**Ribble Valley Borough Council Planning Application Reference : 3/2017/0317**

**Land south of Blackburn Road, Hothersall near Longridge PR3 2YY**

**Independent Review of the Highway Proposals for the  
Planning Application on Behalf of Hothersall Parish Council**

**9<sup>th</sup> May 2017**

Max Legal Articulated Vehicle - IN

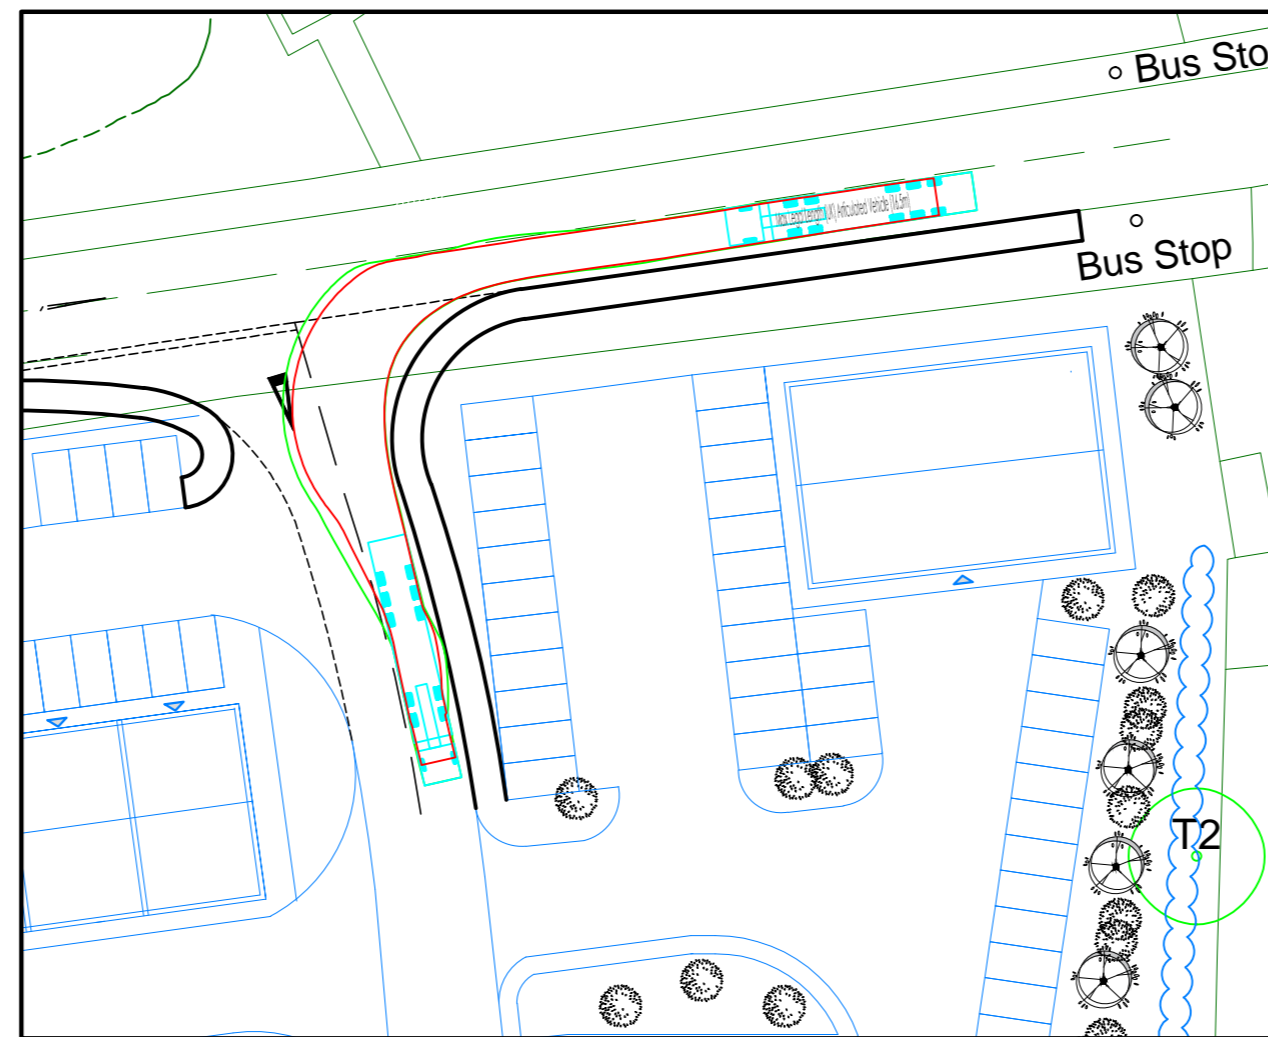
3.9 The proposed junction layout drawing shows that an articulated lorry would have to use the opposite side of the carriageway on Blackburn Road to make a left turn into, or out of, the proposed development. This would present a significant road safety risk to other road users on Blackburn Road where there is a relatively high volume of traffic travelling on this rural section of road with a 60 mph speed limit.
